CITY OF ALBUQUERQUE

September 7, 2016

**Re: Las Ventanas at San Isidro
3737 San Isidro NW
Request Permanent C.O. - Accepted
Engineer's Stamp Dated 3-23-13 (File: G13D031)
Certification dated: 8-31-16**

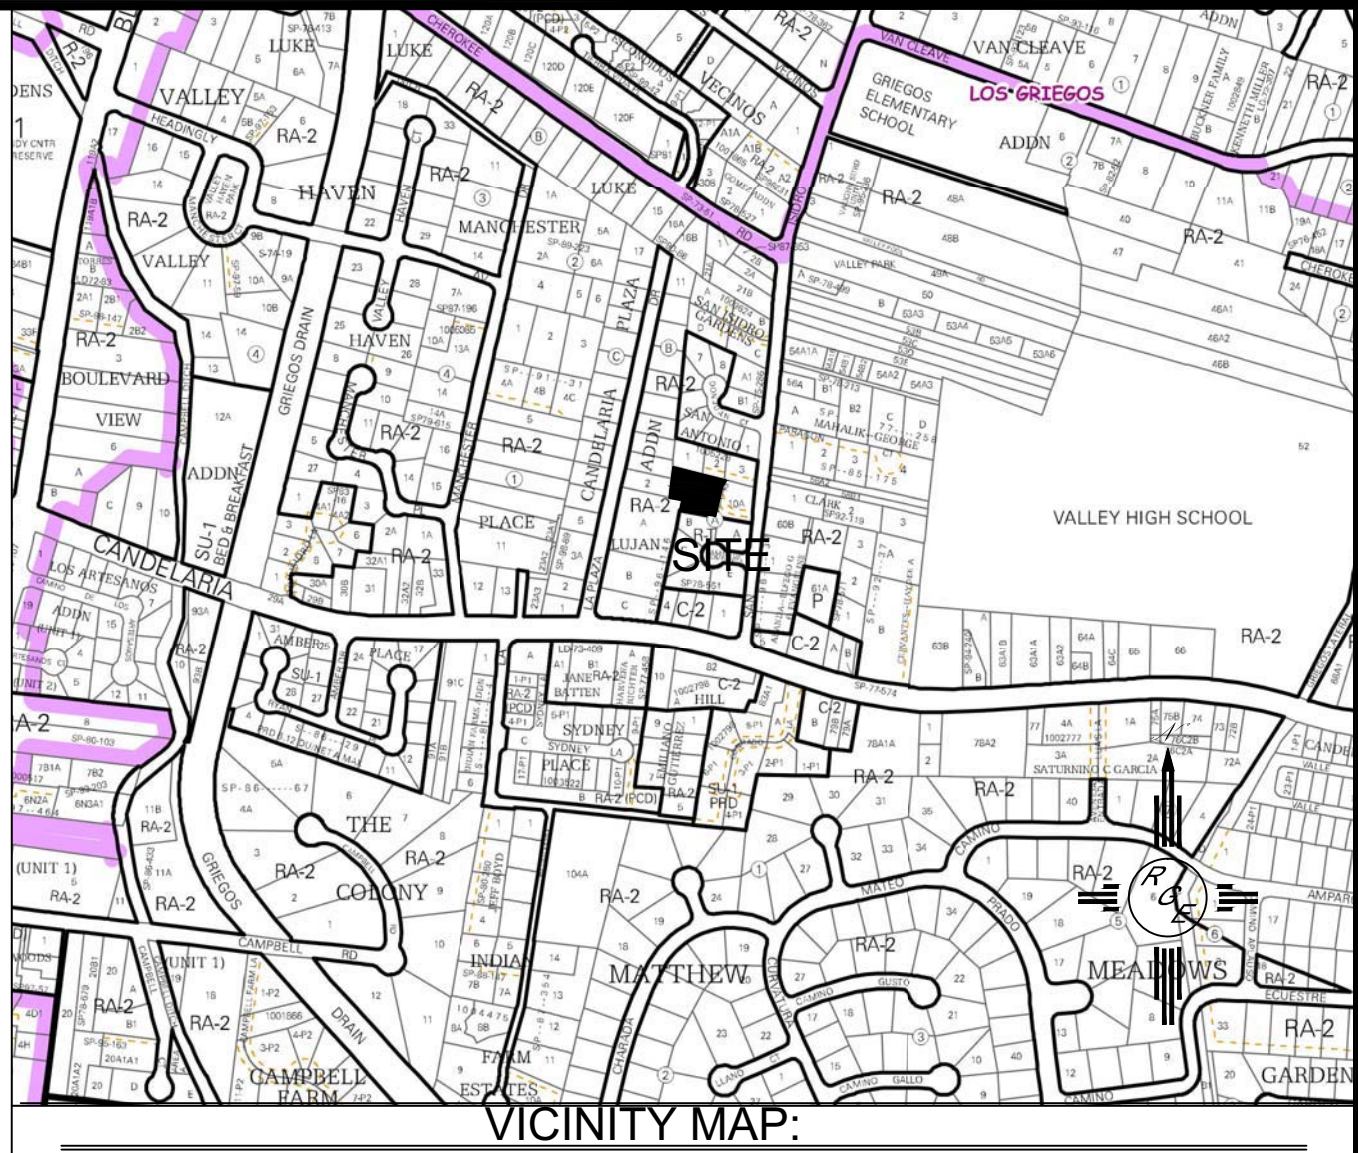
- Both ponds are present however neither is landscaped. During the landscaping phase the volume (size), shape and integrity of the ponds must be maintained per the City of Albuquerque drainage ordinance.
- The ponds must be stabilized with landscaping within 90 days from the date of this letter.
